**85 HARRINGTON STREET
THE ROCKS**

ACCESS REVIEW

Morris Goding Accessibility Consulting

25th January 2016

SCALE	1:200 @ A2	PROJECT CODE
DATE	11/09/2015	GA85H
SHEET NO.	DA-2013	REVISION
		I

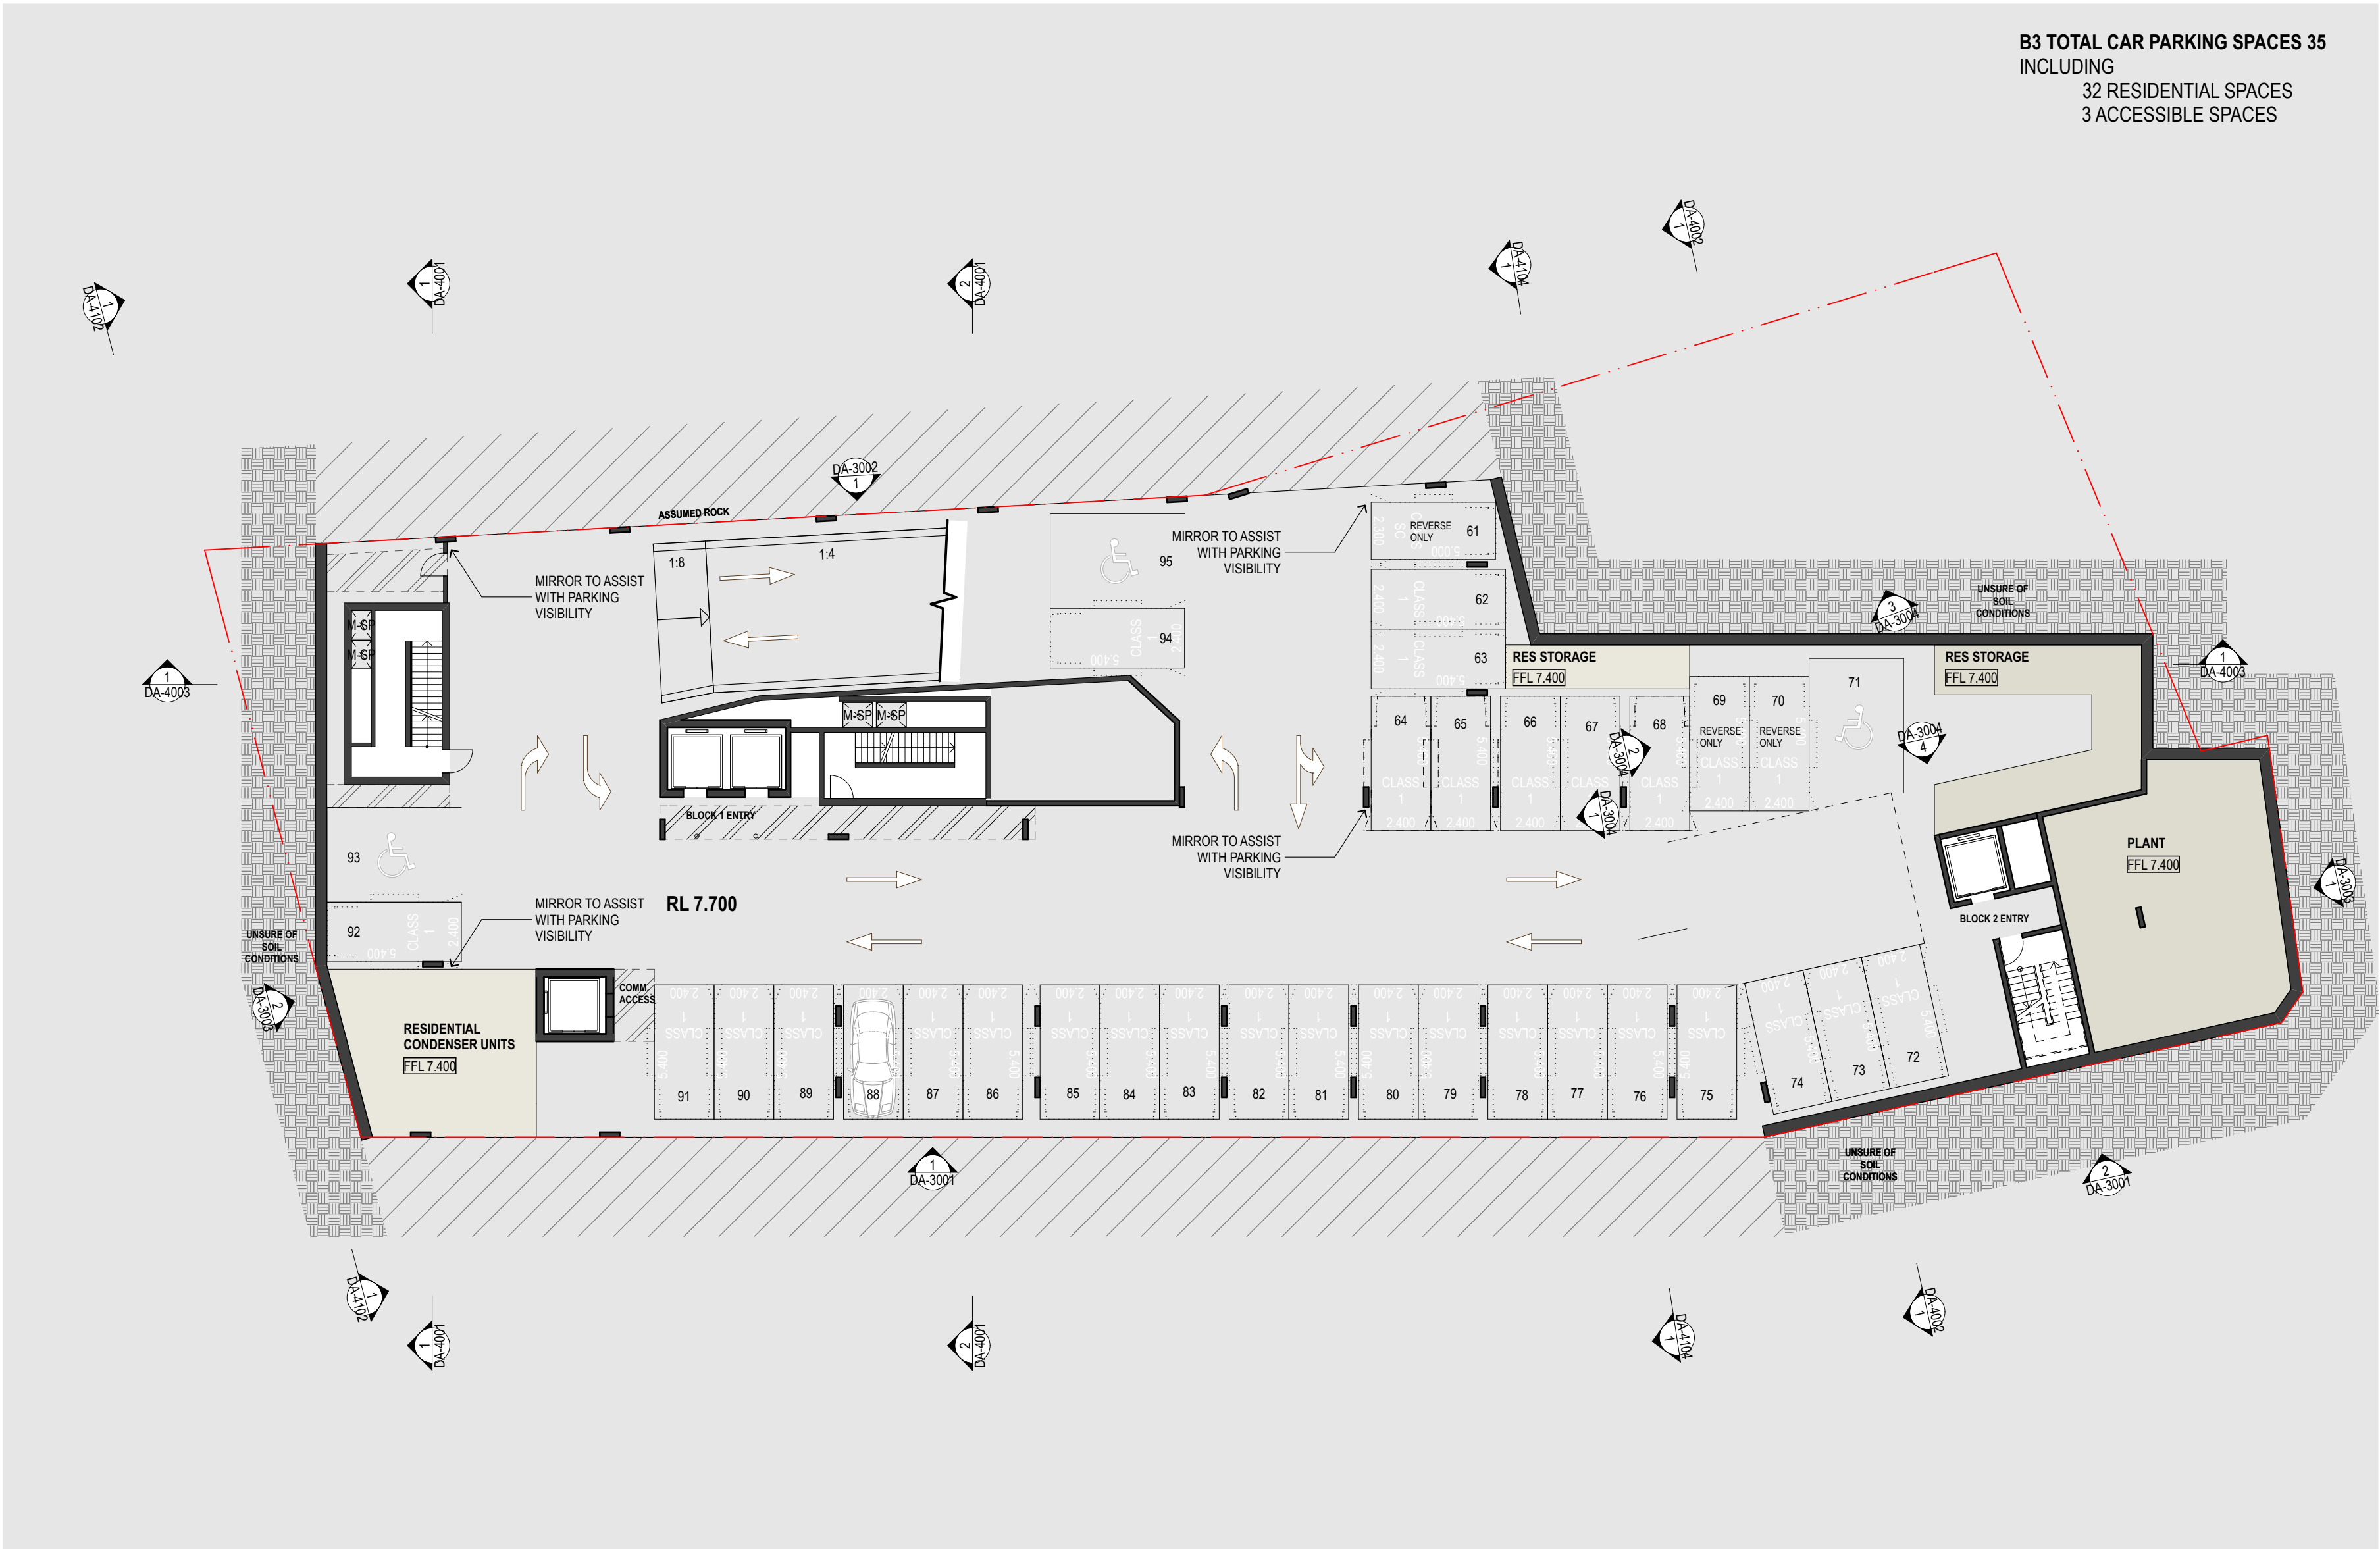
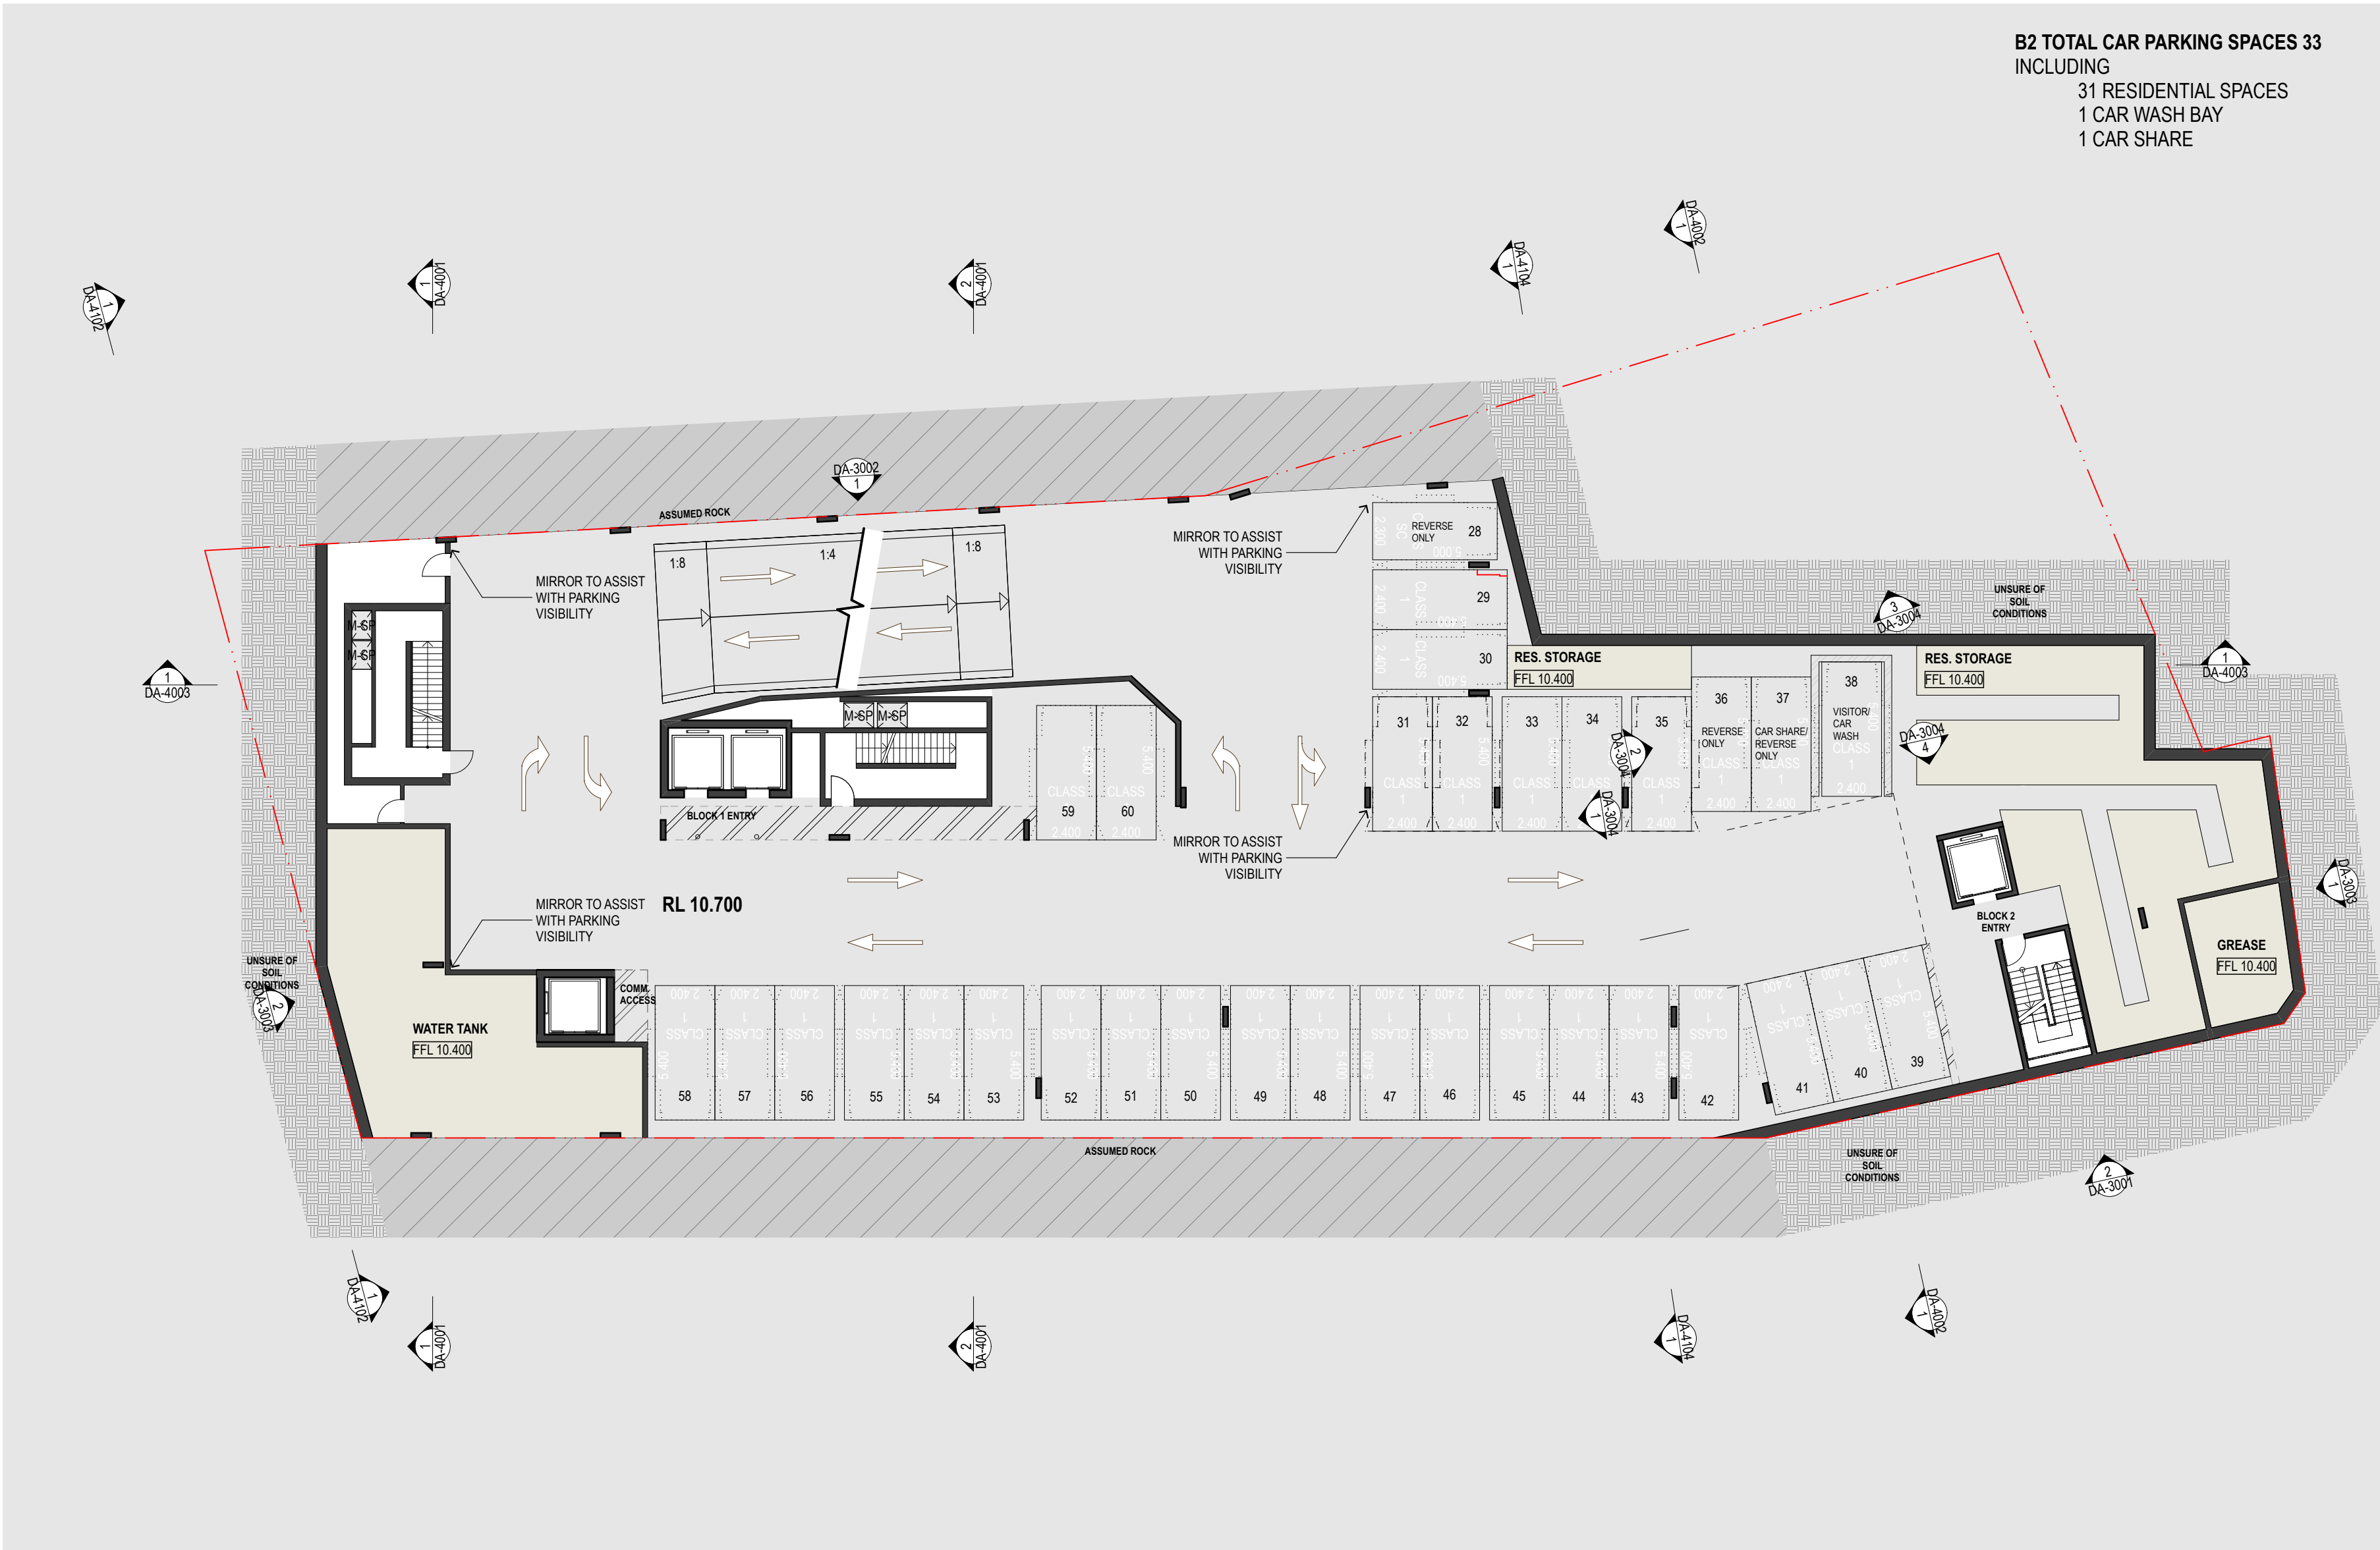
From the documentation provided there are 3 accessible car spaces provided within the Basement car parking levels, in the configuration of 3.8m x 5.4m compliant with AS4299. There are seven adaptable units provided. Review is required to provide a total of 7 accessible car spaces within the Basement car parking levels.

From the documentation provided it is unclear if retail and commercial car parking spaces are to be provided.

- (i) Provide 7 accessible car bays to be designated as adaptable car bays at the rate of 1 accessible car space/adaptable unit, compliant AS4299.
- (ii) Ensure the accessible car spaces for the adaptable units are 3.8m x 5.4m, compliant with AS4299 or alternatively 2.4m x 5.4m with a 2.4m shared zone adjacent, compliant with AS2890.6.
- (iii) Ensure accessible/adaptable car spaces are located in close proximity to relevant lift core (location of apartment).
